**RE: Ladera Self Storage  
Conceptual Grading and Drainage Plan  
Engineer's Stamp Date: 05/03/18  
Hydrology File: H09D001F**

Based upon the information provided in your submittal received 05/03/18, the Conceptual Grading and Drainage Plan is approved for action by the DRB for Preliminary Plat and Site Plan for Building Permit.

Your submittal **is not** approved for Building Permit and SO-19 Permit. The following comments need to be addressed for approval of the above referenced project:

C.01

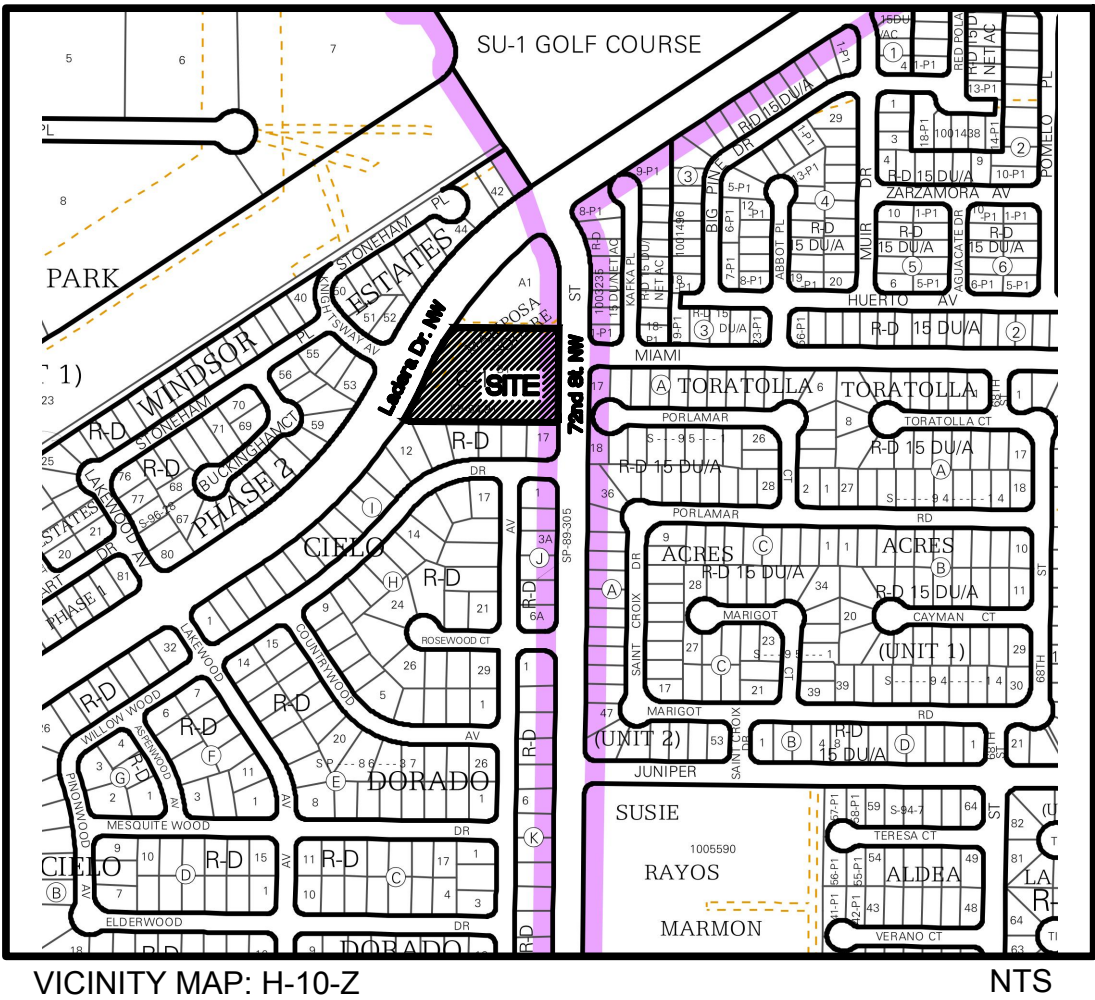
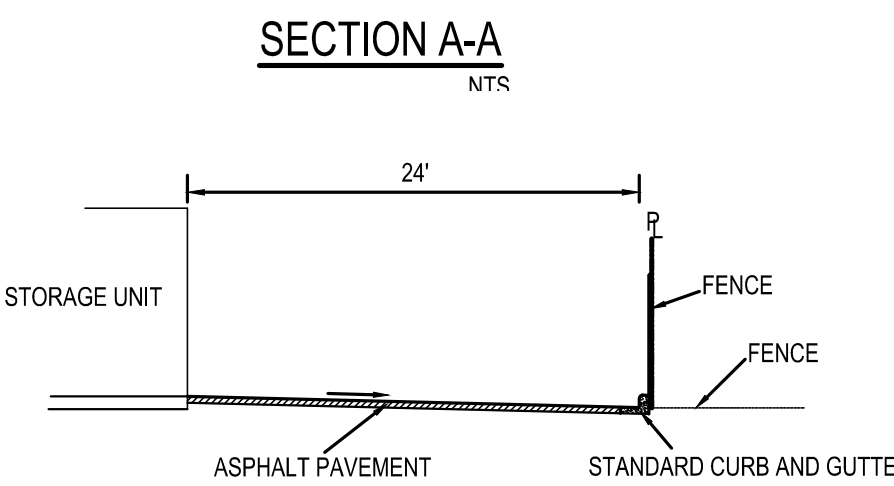
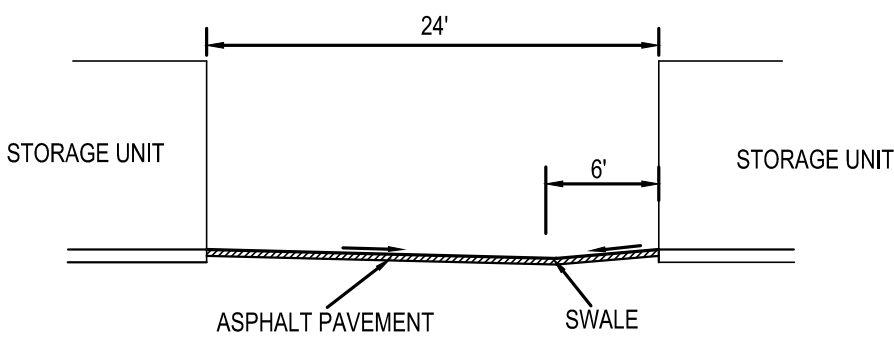
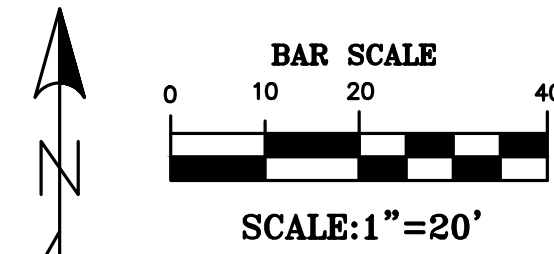
1. Please provide the SO-19 Notes. I have attached them for your use.
2. Please provide weir calculations for 24" curb cuts, 24" sidewalk culvert, and 12" concrete channel.
3. Please change Key Note #4 from a 12" sidewalk culvert to a 12" concrete channel. This is not going under a sidewalk, so there will be no steel plate needed.
4. Please provide first flush calculations.
5. Please provide a typical cross section of the first flush pond to include the storage unit and the property line with dimensions. Also show if the ponds are to be gravel or just dirt.
